From: Zac Denton
Sent: 23 July 2019 09:02
To: Planning Scanning
Subject: FW: Mistletoe Farm, Horsemere Green Lane. CM/13/19/RES; Revised Drainage Proposals
Attachments: ES1820-602-04 B Drainage Strategy with Ditch.pdf

MISTLETOE FARM
LITTLEHAMPTON

Drawing Title				
Engineering Details				
Drainage Strategy (with Ditch)				
Drawn	Checked	Scales	Paper Size	Date
KN		1:250	A1	07.19
Job No.	Drawing No.	Revision		
ES1820	602-04	B

Drawing Title				
Engineering Details Drainage Strategy (with Ditch)				
Drawn	Checked	Scales	Paper Size	Date
KN		1:250	A1	07.19
Job No.	Drawing No.	Revision		
ES1820	602-04	C

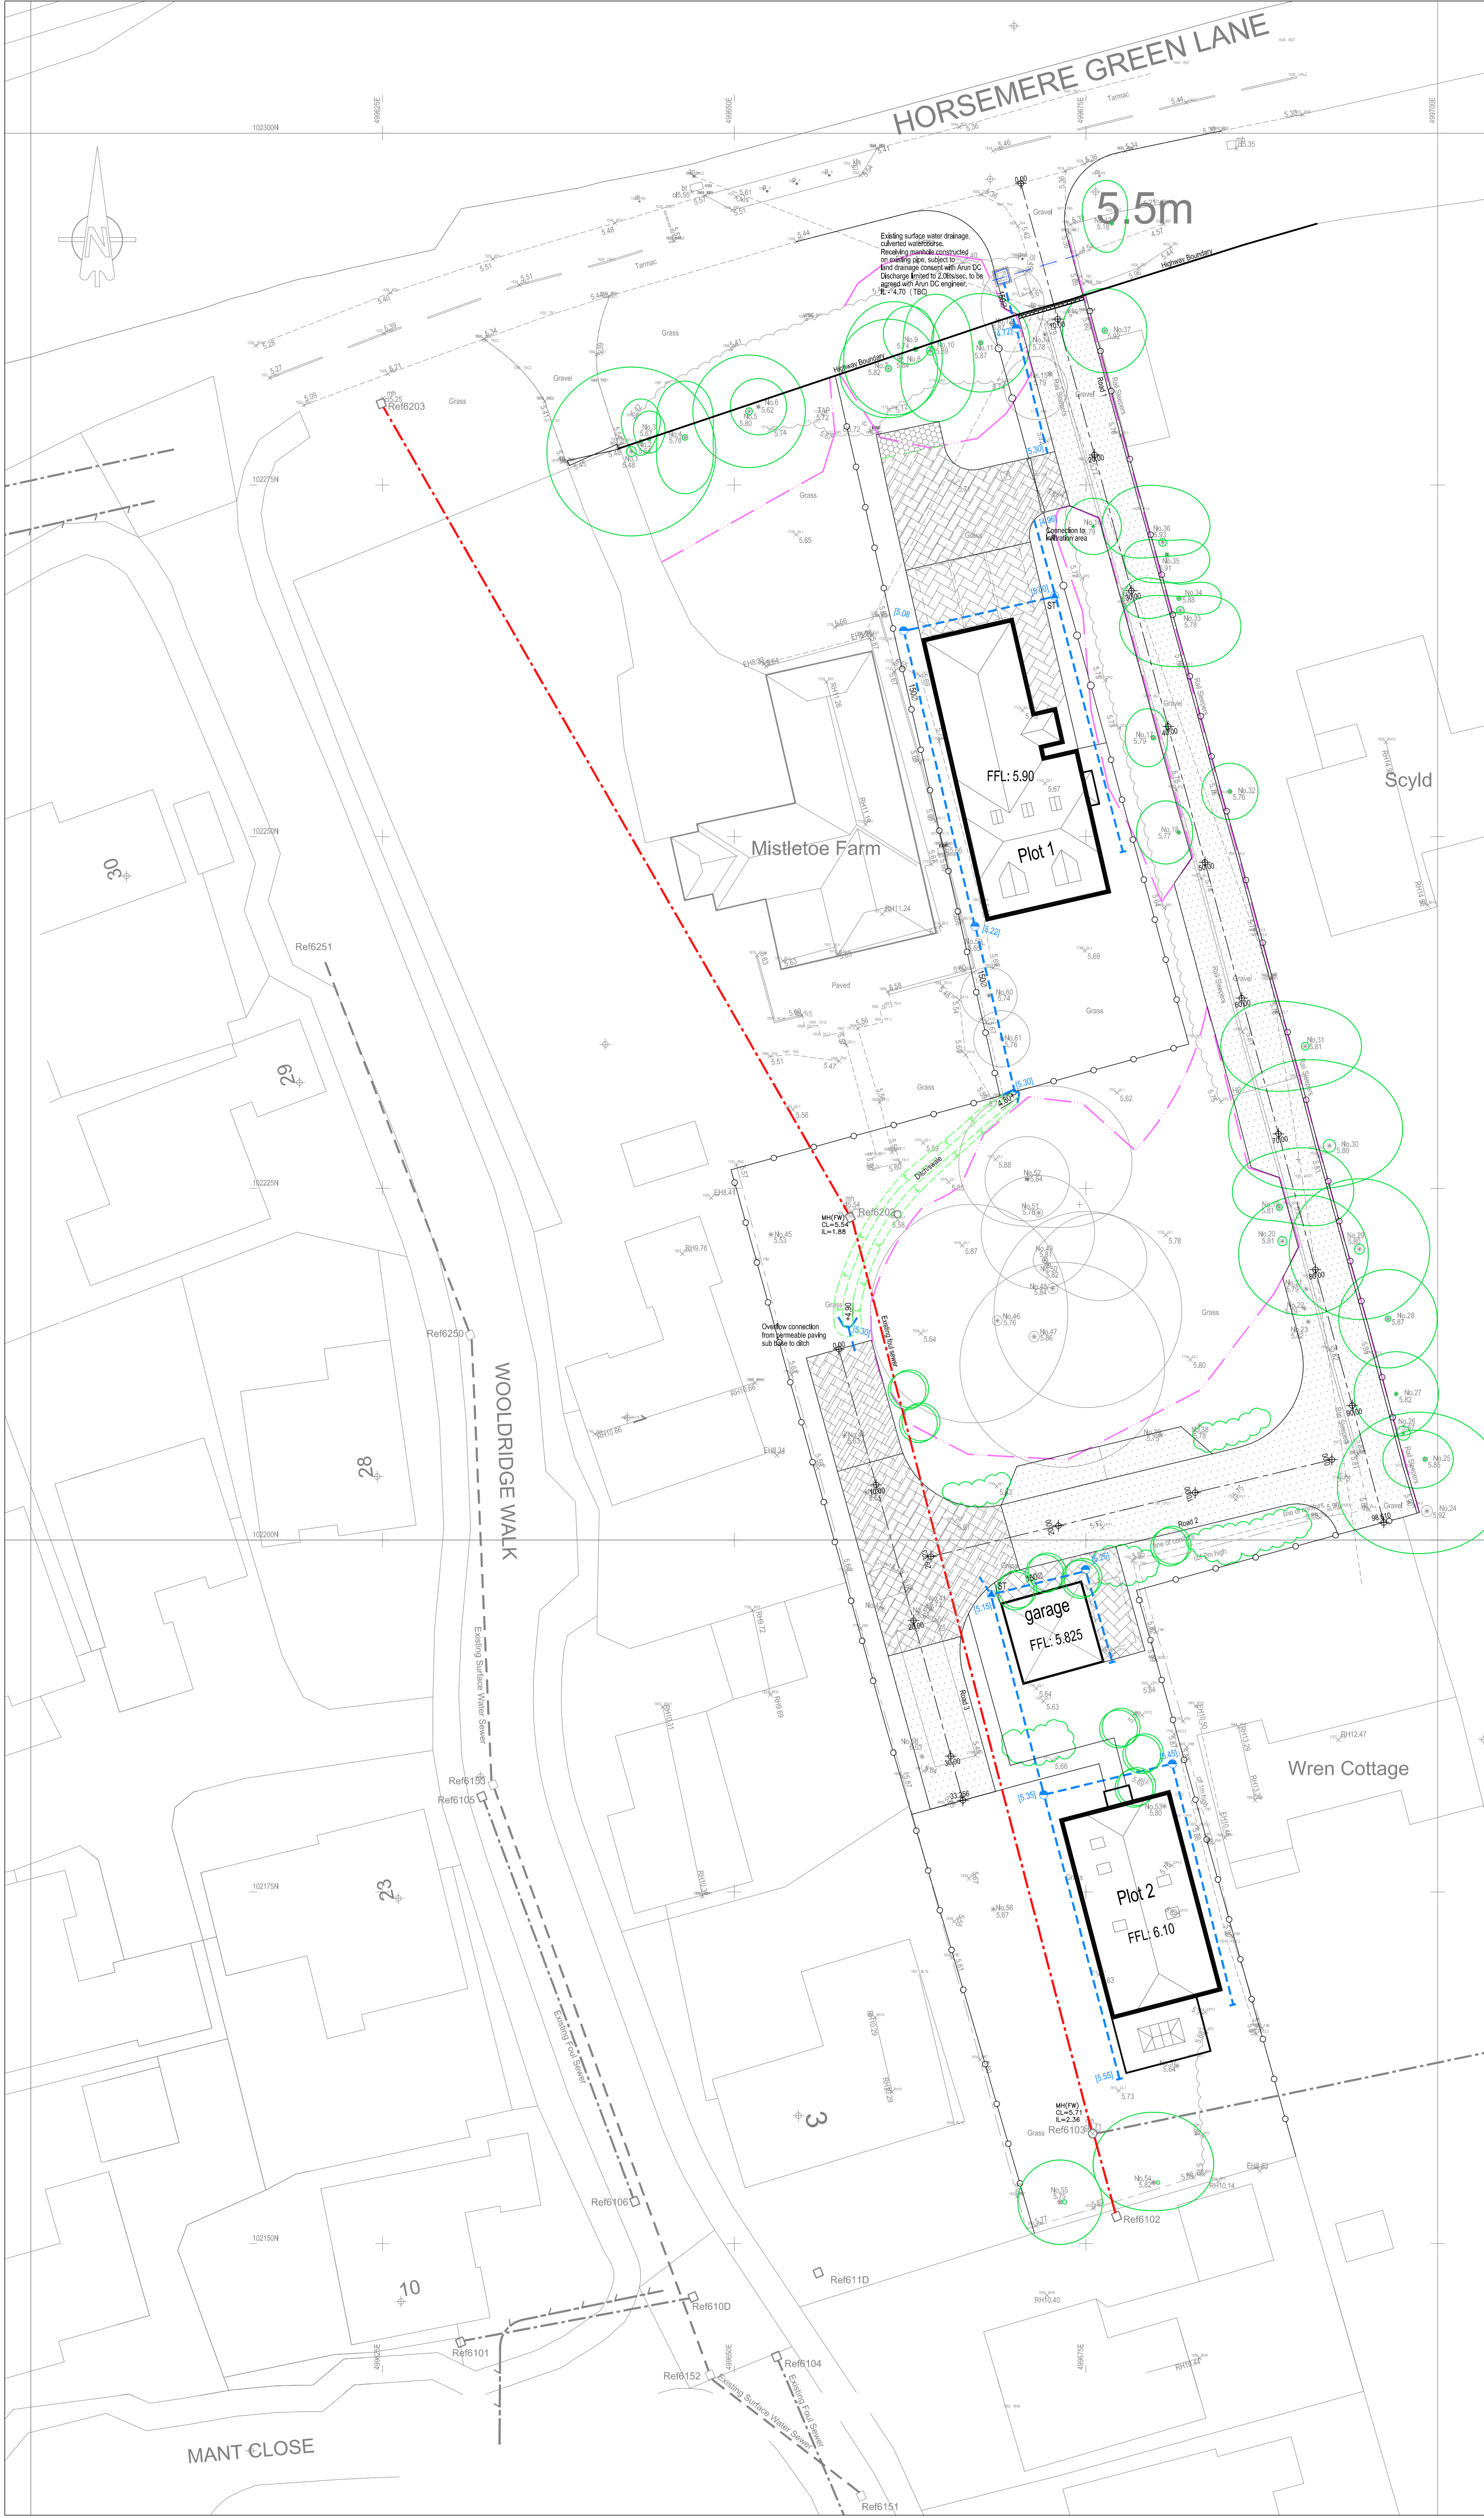
Thank you for sending over the revised plan. I believe there is some conflict between what you are proposing and the tree protection plan (attached).

The permeable paving for plot 2 looks like it could only be located in the T furthest round on the road rather than at the junction of roads 1 and 2. The swale also appears to be within a no dig area.

Thank you for your comments. I was under a misapprehension regarding the RPZ so having cleared that I have put together a revised proposal which addresses your comments on the RPZ. Hopefully you find this revised proposal accords with your thoughts and you are able to advise your planning colleague that we have reached a drainage solution. As always, if you have any further concerns please contact me. Many thanks.
